From: [REDACTED]
Sent: 03 March 2019 11:28
To: Andrew Wood
Subject: planning application FG/220/18/PL New house in garden of Elm Lodge, Tamarisk Way, Ferring, BN12 5ER

Having carefully examined this application against the policies embedded in the Arun Local Plan, we believe that the application contravenes these policies in the following ways:-

PROPOSED ROOF PLAN AND
PROPOSED ELEVATIONS

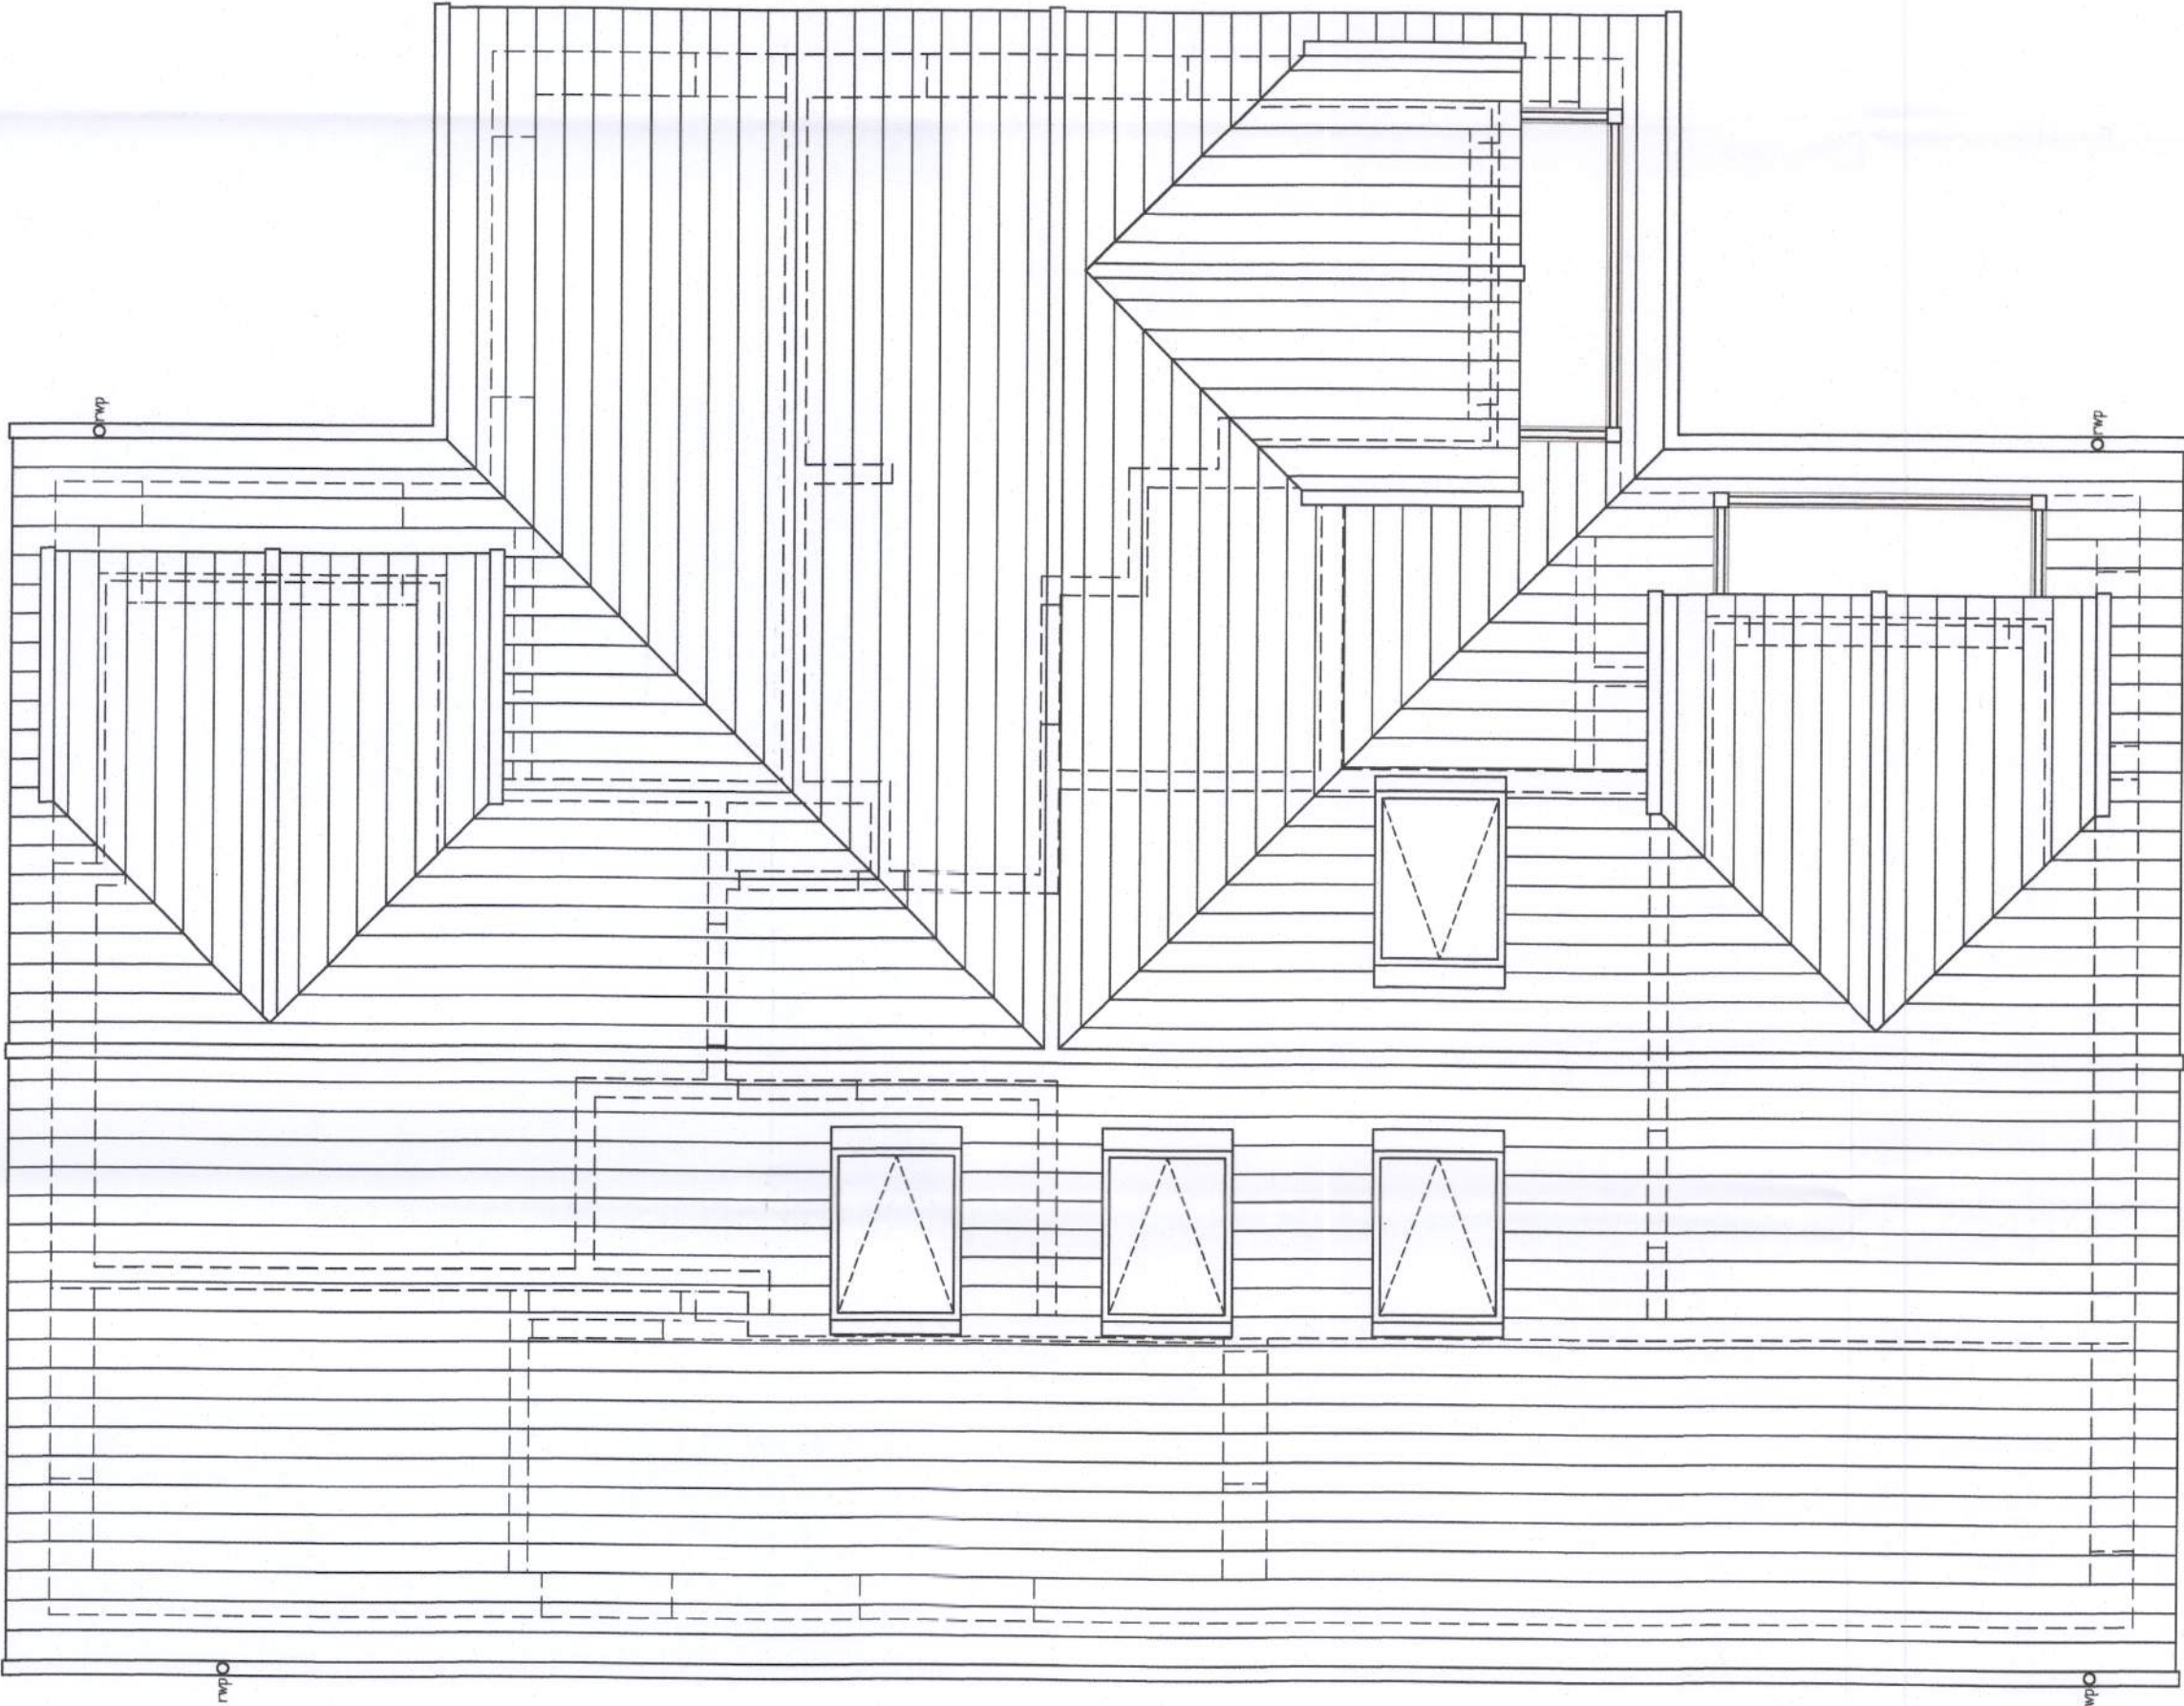
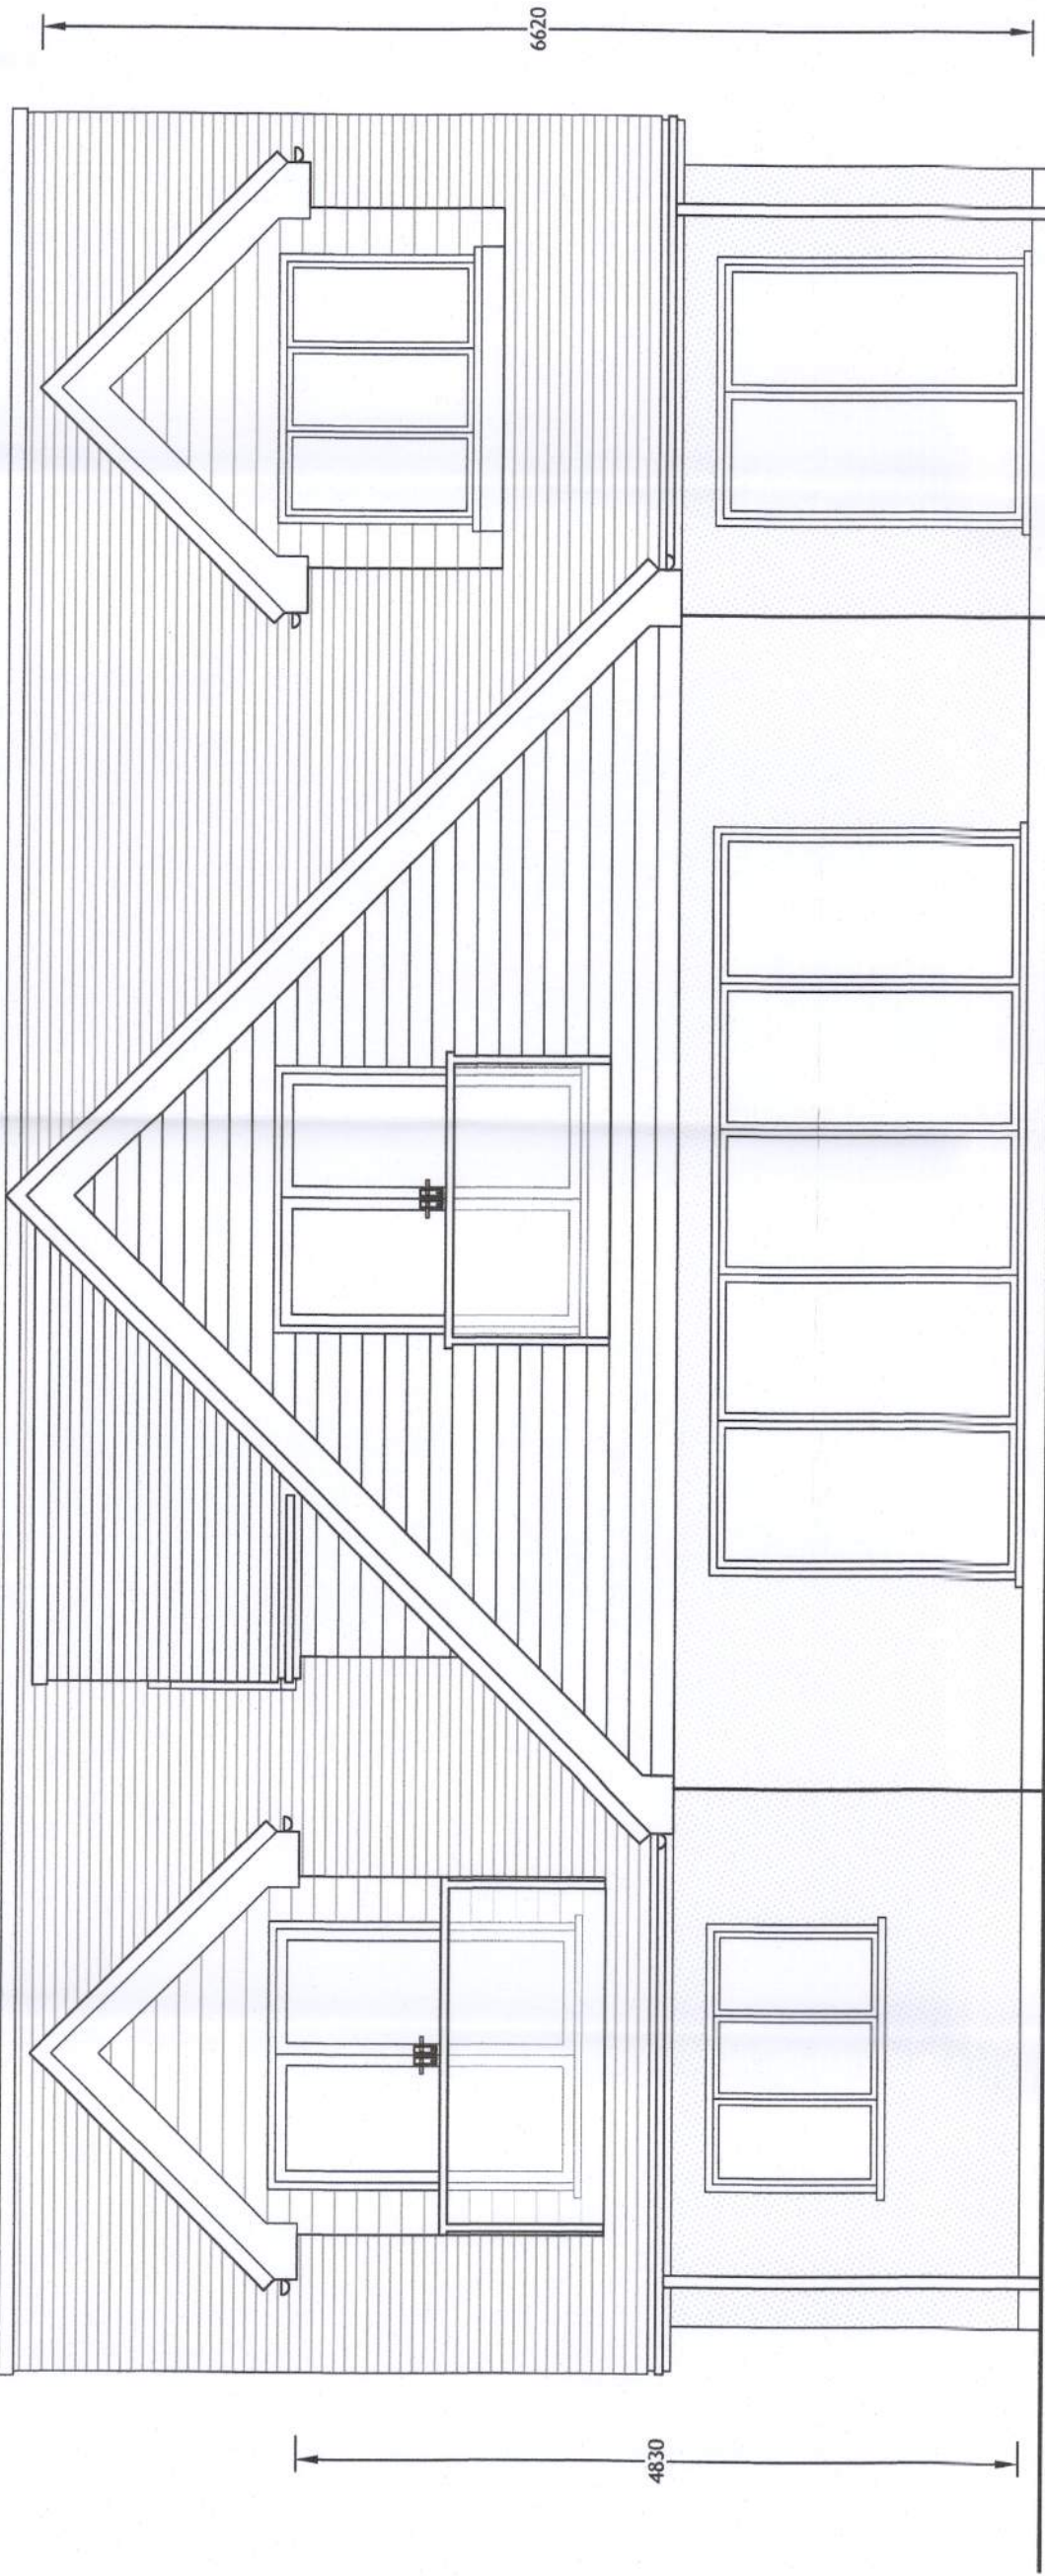
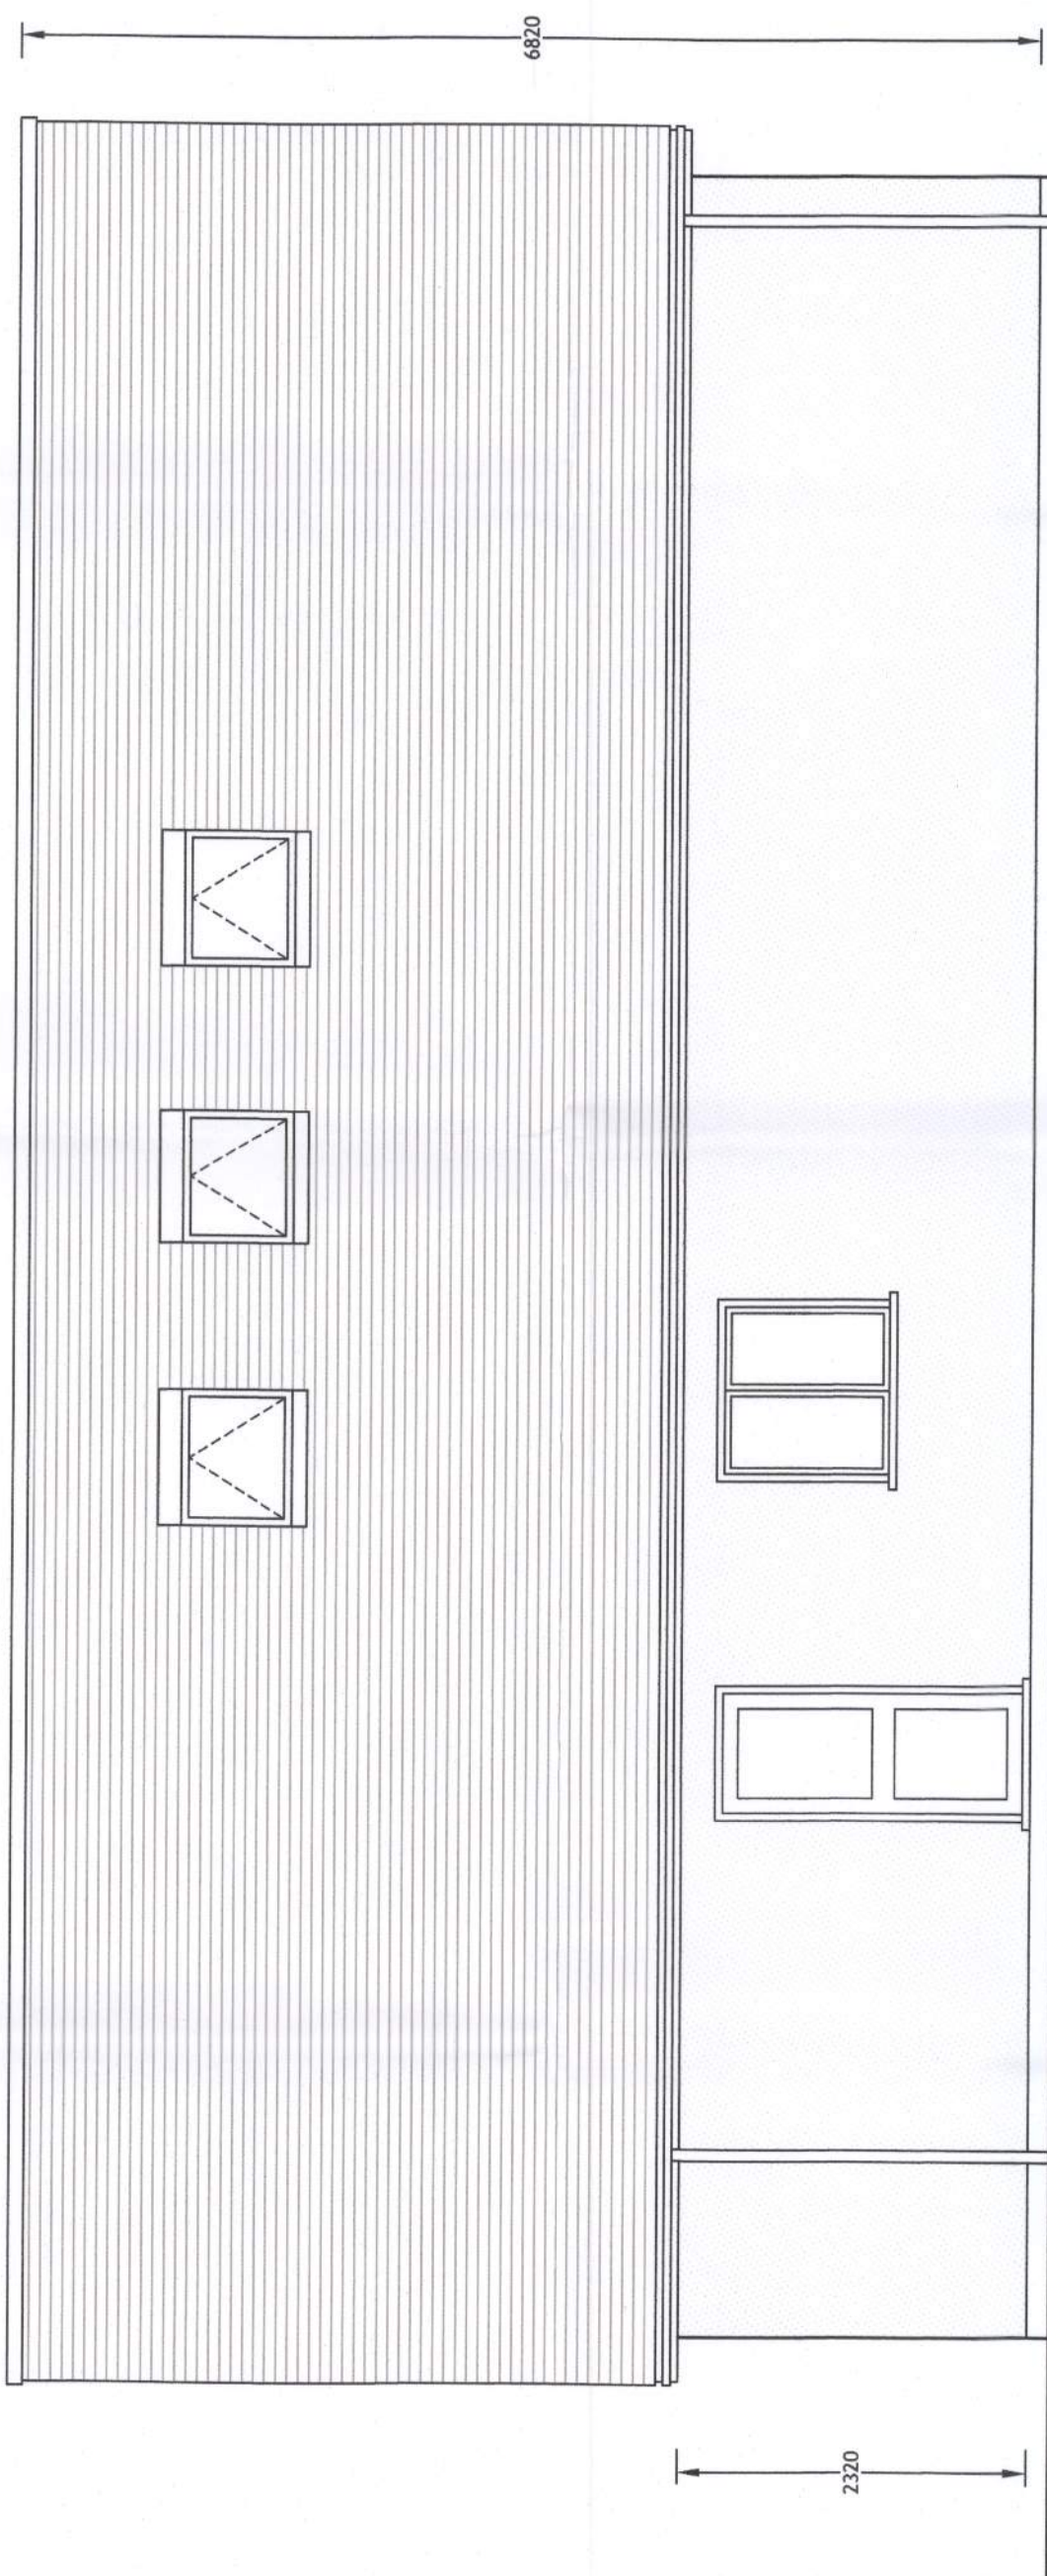
The proposed house plans call for 3 full length balcony windows on the first floor, 2 of which will look down directly into habitable areas and gardens of Magalia (one of these windows fully covers the entire 1st floor gable). We would point out that this is in addition to a third window which is to be installed in Elm Lodge and which is in fact less than the recommended distance from Magalia (see discussions held at a site visit from a member of the Arun Planning Dept. in November last year). This presents an excessive and unacceptable intrusion of privacy and we believe this to be contrary to the requirements of the Arun Local plan as detailed above

The ‘post- modern’ style of the proposed house and alterations to Elm Lodge are highly suitable for the urban Home Counties, but are completely out of character and sympathy with the houses in and around Tamarisk Way and along Sea Lane. The use of cladding, blue slate tiles and grey windows bears no resemblance to any building materials used in the vicinity of Tamarisk Way and would stand out like a ‘sore thumb’.
